VOLLMER RV STORAGE

GRADING AND EROSION CONTROL PLAN

EPC STORMWATER REVIEW COMMENTS IN ORANGE BOXES WITH BLACK TEXT

PPR-22-045

**DP\_01 PROFILE**  
STA 1+00.00 TO 4+24.00

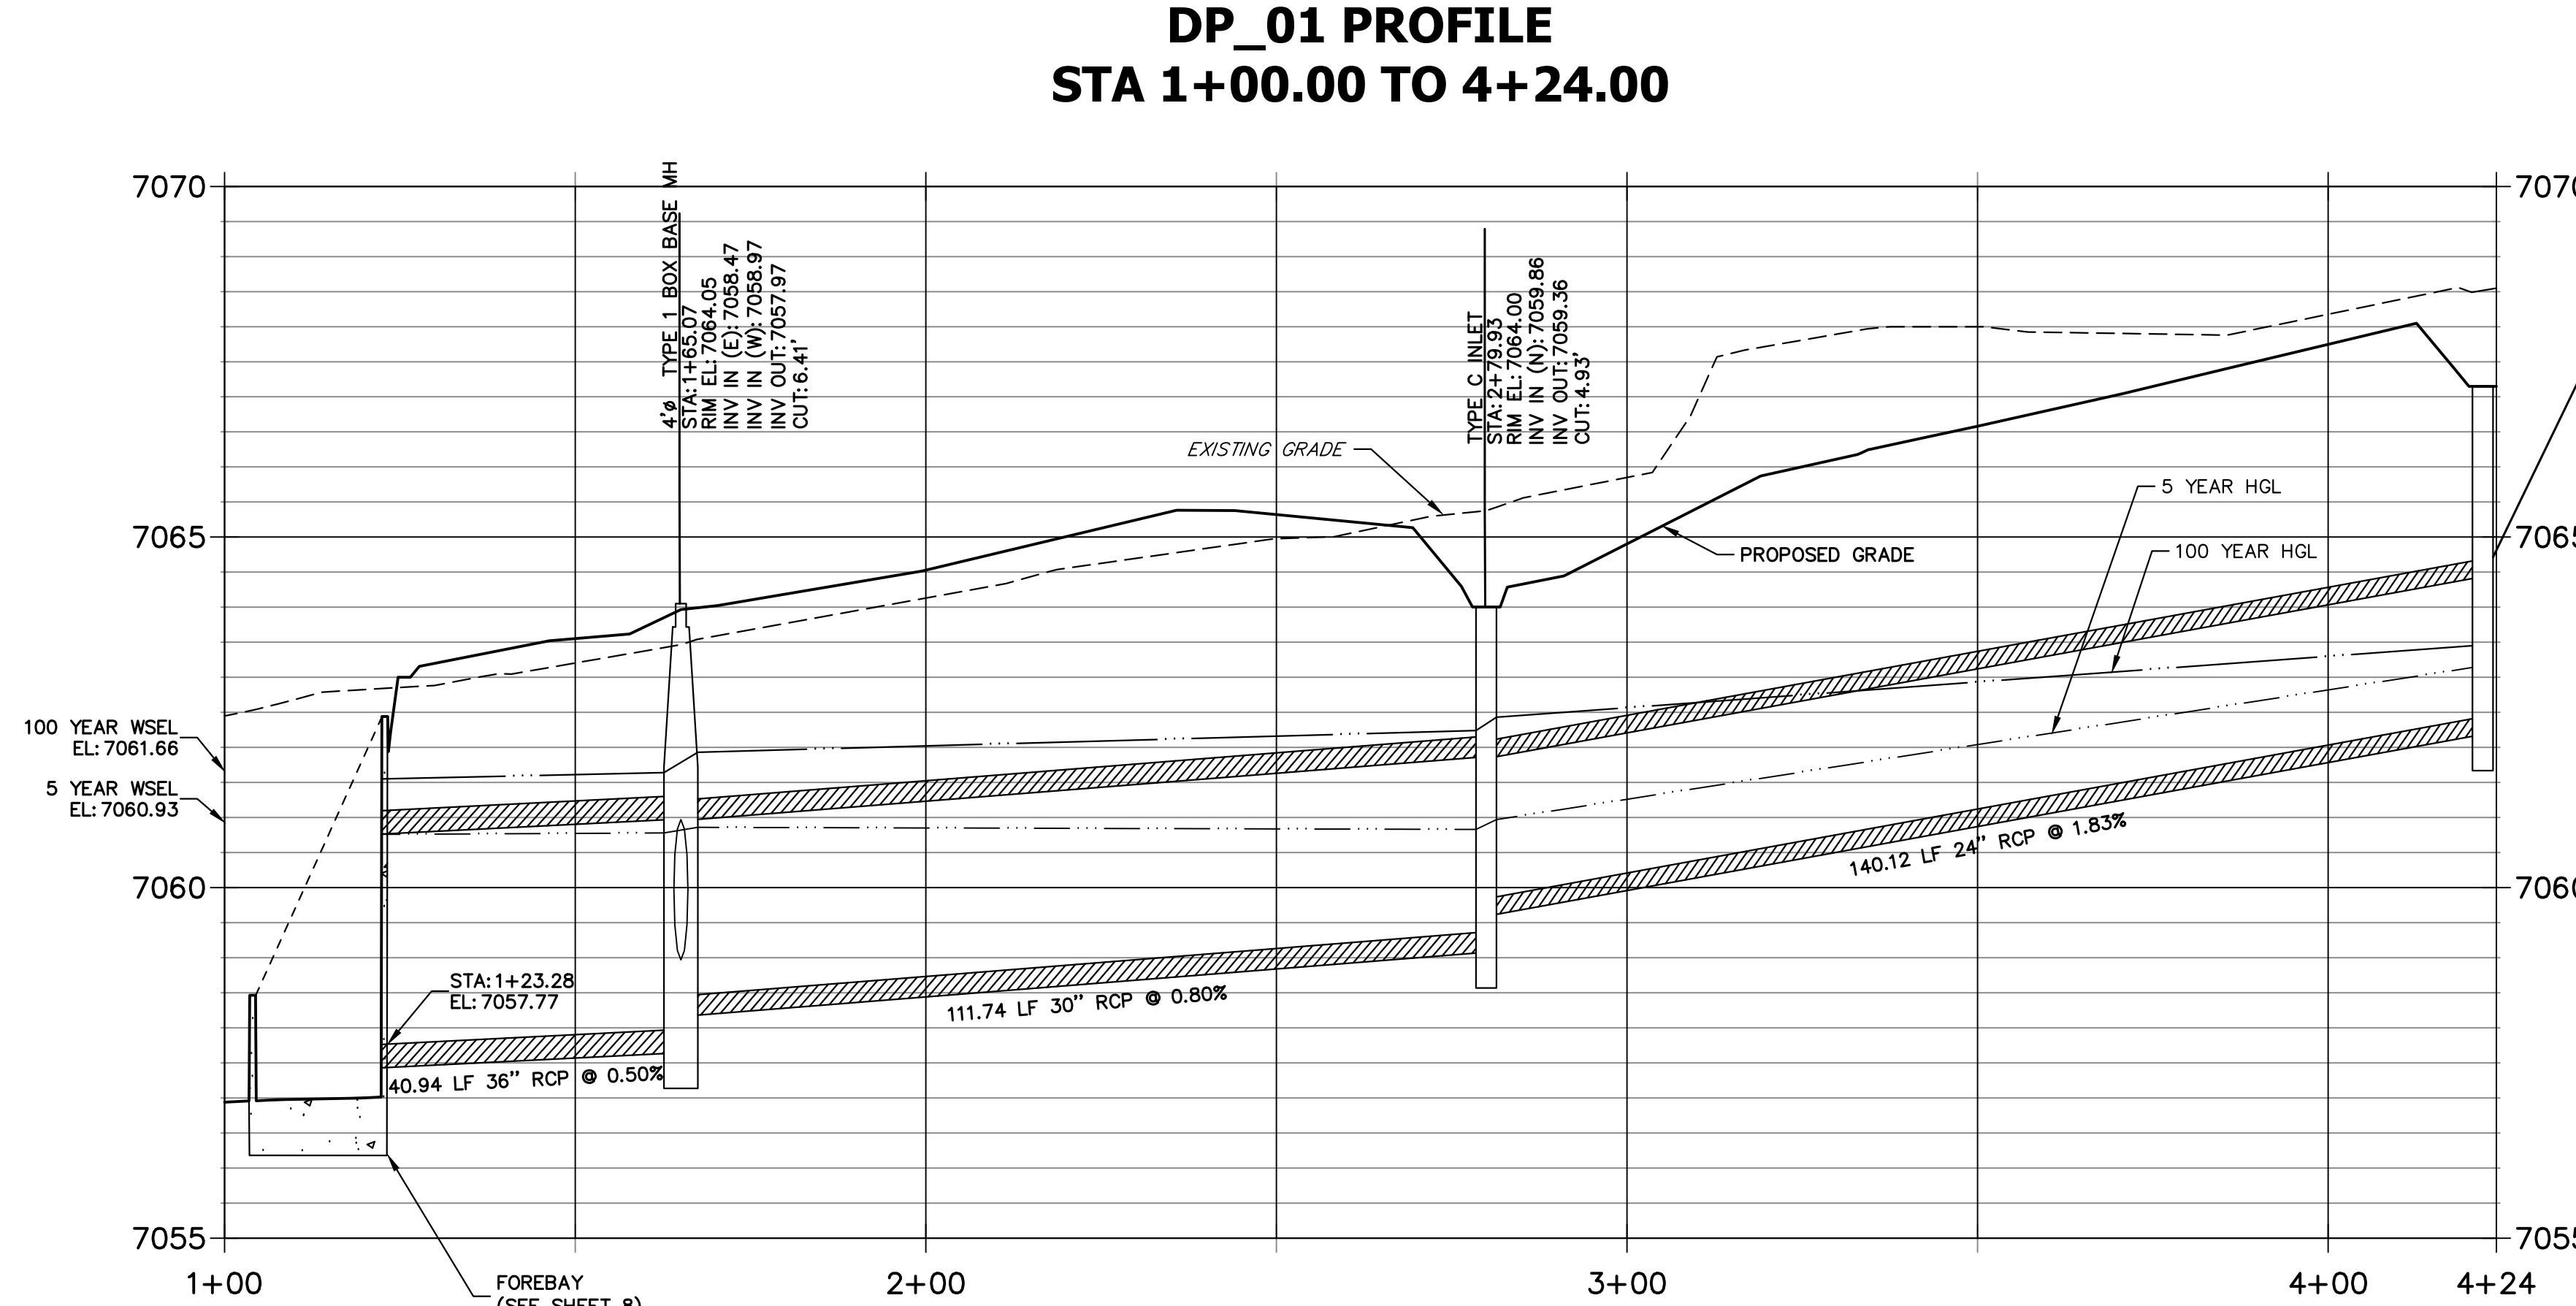
Grading plan does not indicate an elevation 7068 on this side of area inlet

Provide a label for structure so know what it corresponds with in other profile
